CITY OF PORTLAND HOUSING CODE  
DWELLING UNIT COMPLIANCE

Location: 85 Avalon Rd 297-E 019

**Inspection Violations**

<b>Owner/Manager</b> DONGO ROBERT J & KELLEY C JTS		<b>Inspector</b> Doug Morin	<b>Inspection Date</b> 8/18/2015
<b>Location</b> 85 AVALON RD	<b>CBL</b> 297 E019001	<b>Status</b> Failed	<b>Inspection Type</b> Building-Legalize Nonconforming

2B: Dimensioned Floor Plan

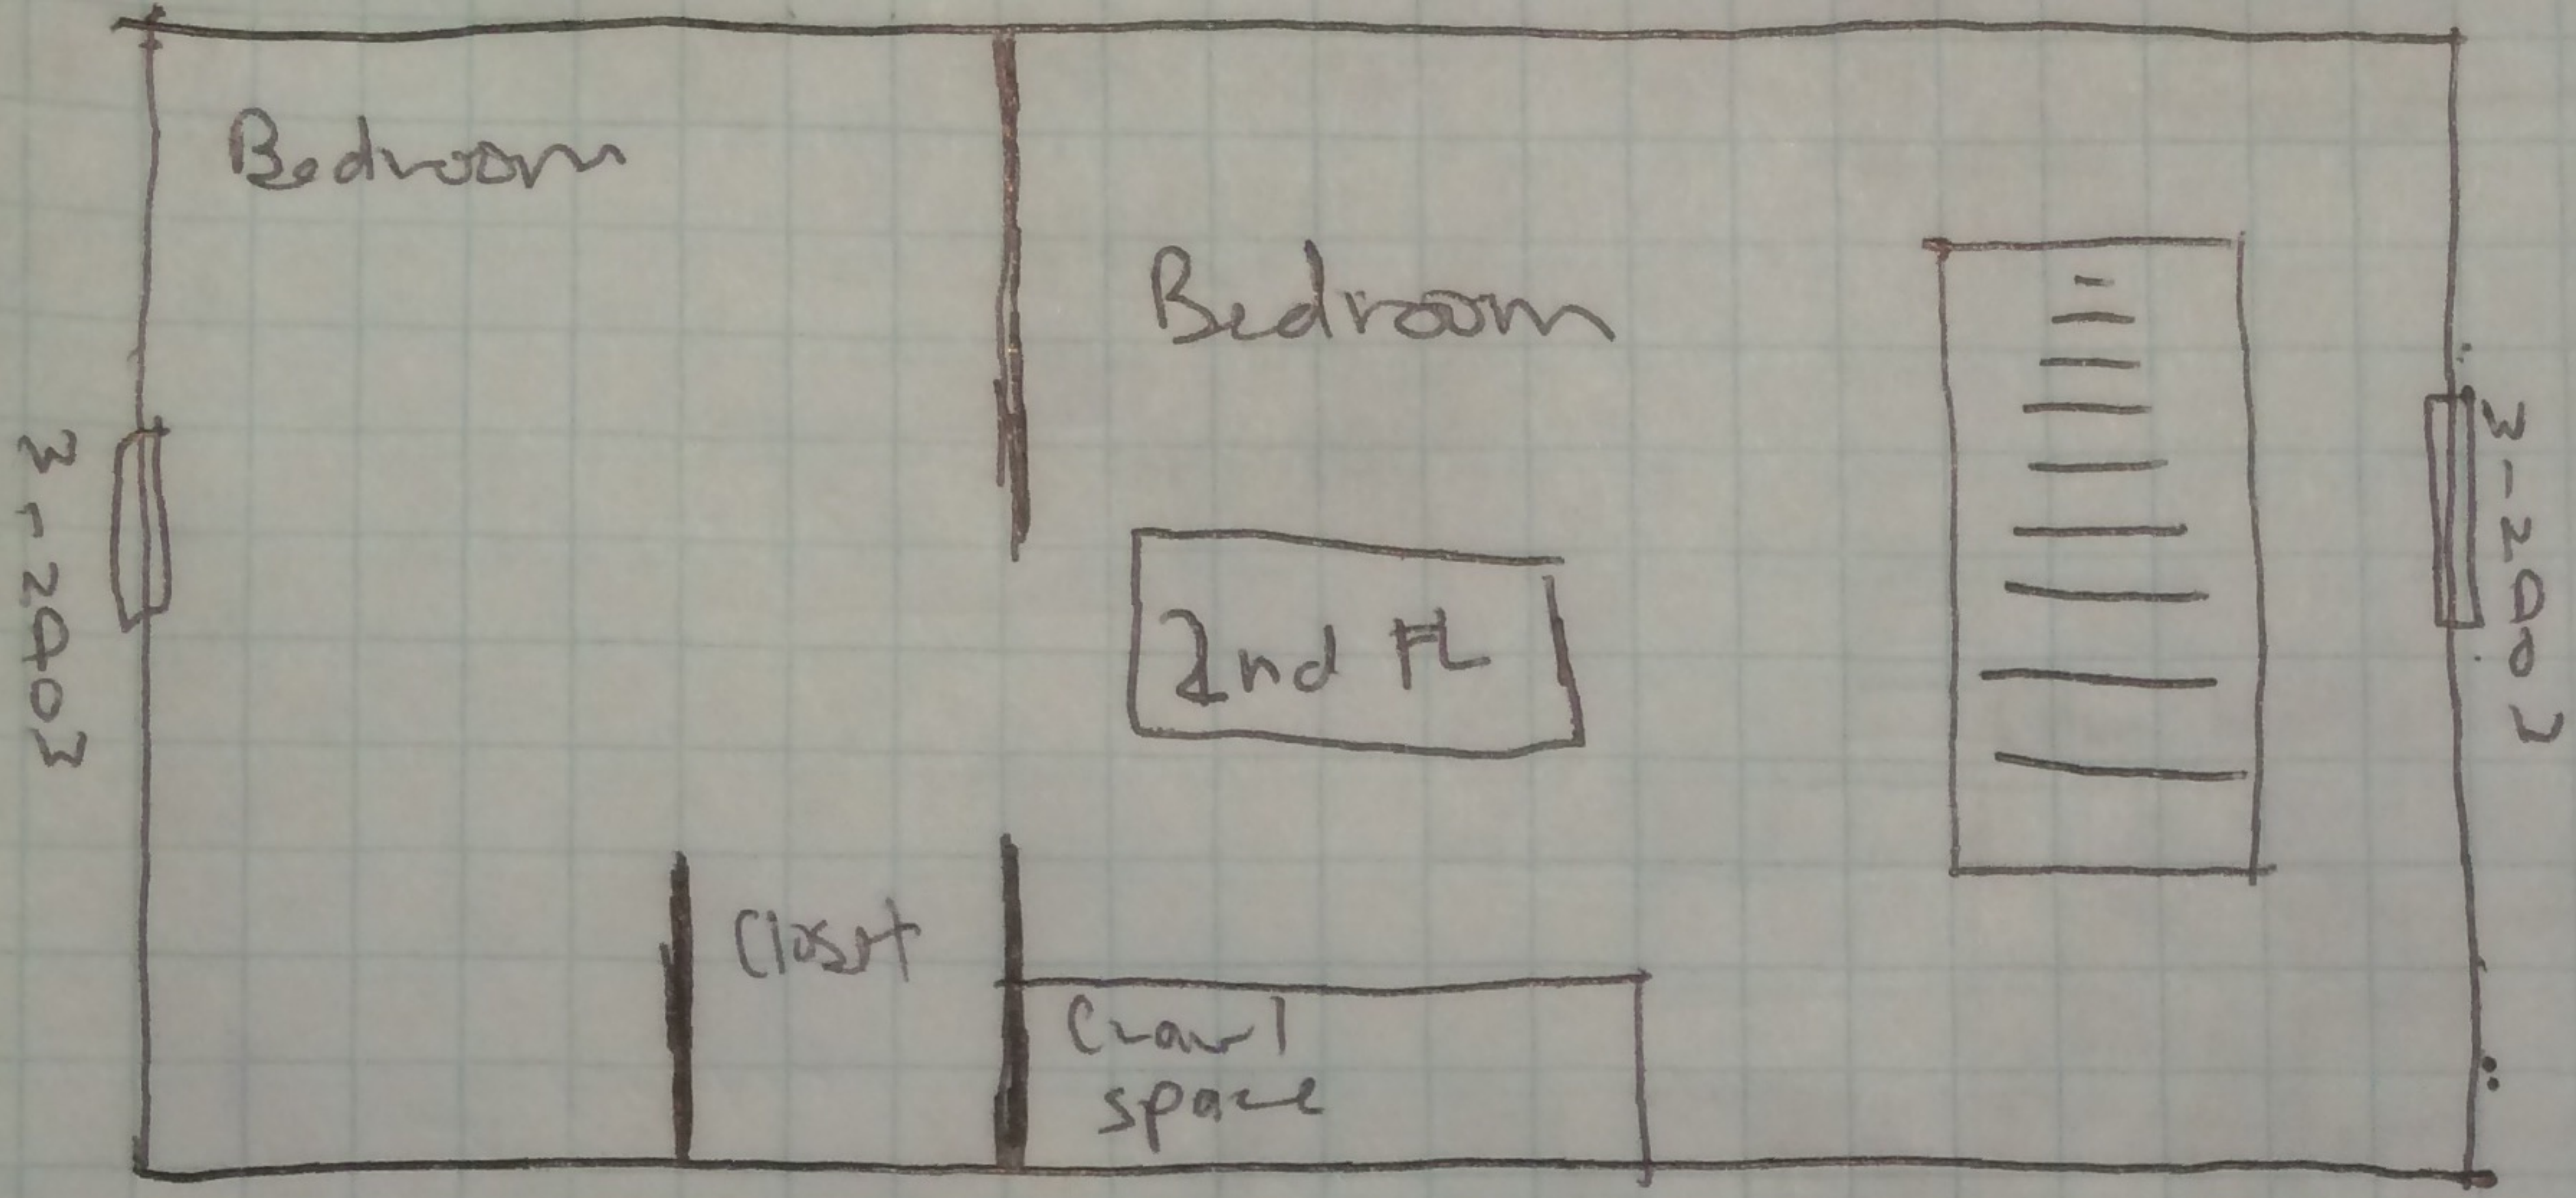
**Comments:** 2nd floor is non habitable. Ceiling height is 6"-9" at center only with sloped roof (does not meet). Stairs leading up to 2nd floor on non compliant as well, would have to be done to code. GFCI protection needed in kitchen and bathroom. Also other electrical upgrades for boxes with exposed wires with no outer insulation. Plumbing should be upgraded for health and safety reasons. It appears the building is less than 5 feet and as close as possibly 3 feet at one point. Will need one hour fire separation construction (5/8 Gypsum) on that side of the property. Owner will apply for a building permit to remove stairs and have a pull down set and create a studio type apartment.
